CITY OF ALBUQUERQUE

June 30, 2016

Re: Drainage Control Ordinance (14-5-2-1) and NPDES CGP Violations for Erosion and Sediment Control – Sol Vita Subdivision

Sol Vita Subdivision
Offsite Work

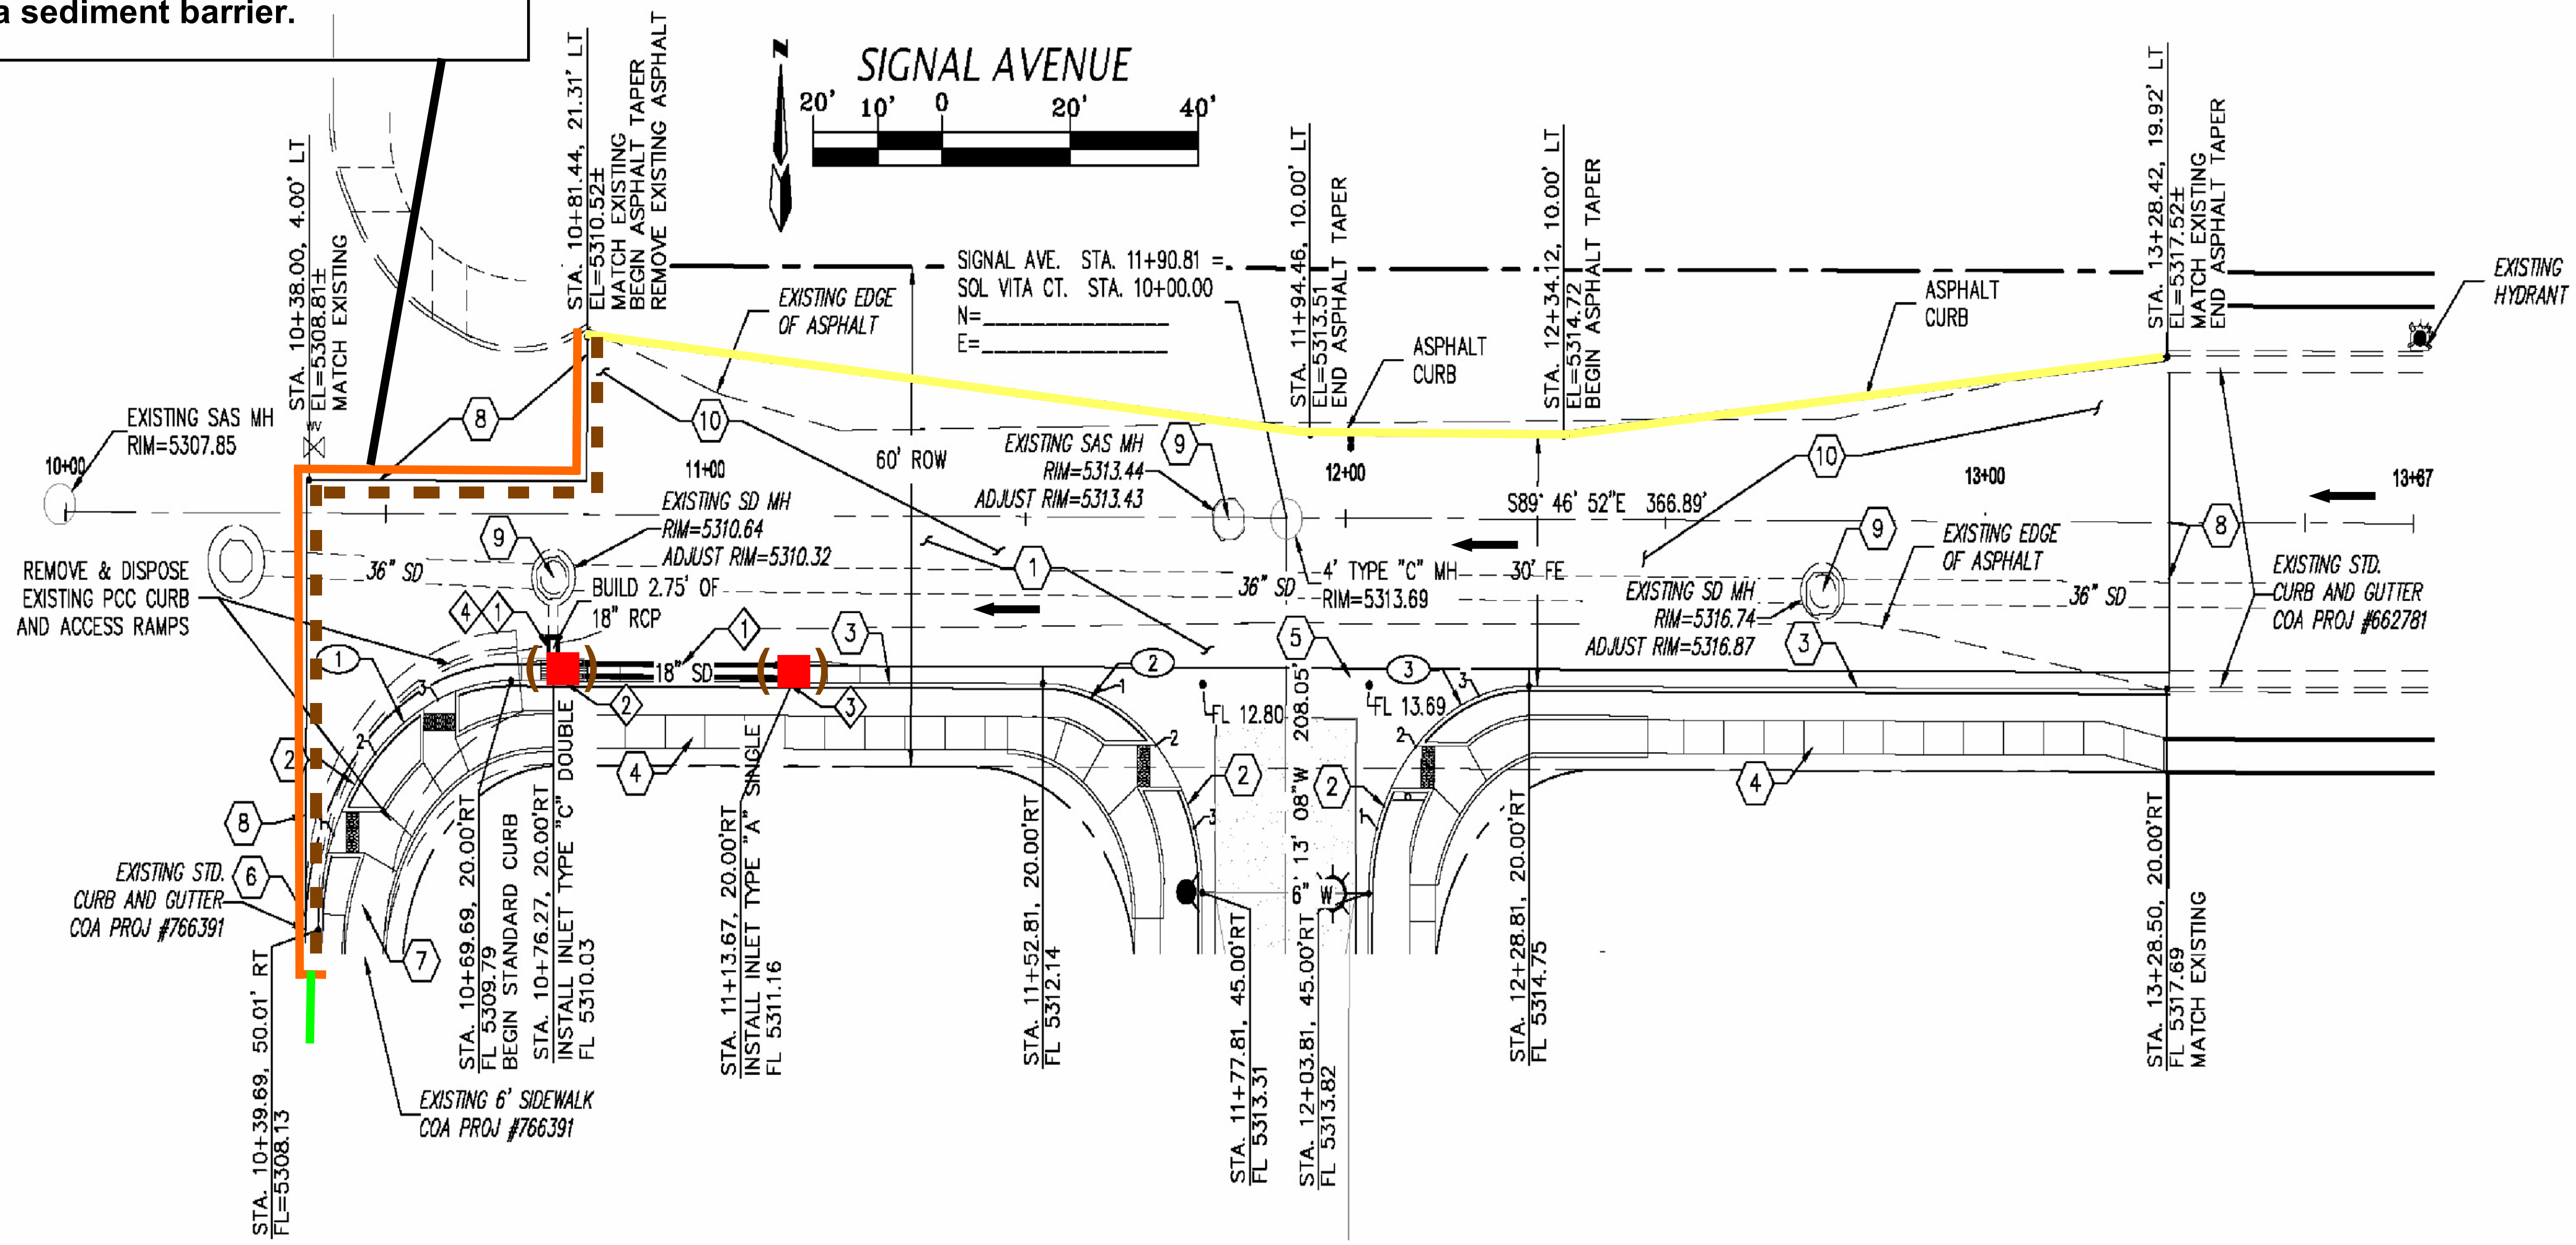
1. Install/maintain silt fence/sediment BMP per approved methods along Signal Blvd. and the southern edge of project.
2. Provide a sediment BMP along Louisiana Blvd. for the land south of the development that is being used for access/staging.

No sediment BMP Signal Ave. west of track-out pad.

No sediment BMP Signal Ave. East of track-out pad.

No sediment BMP southern edge.

Access/staging area outside of project boundaries.

No sediment BMP on Louisiana for disturbed staging/access lot outside of project boundaries.
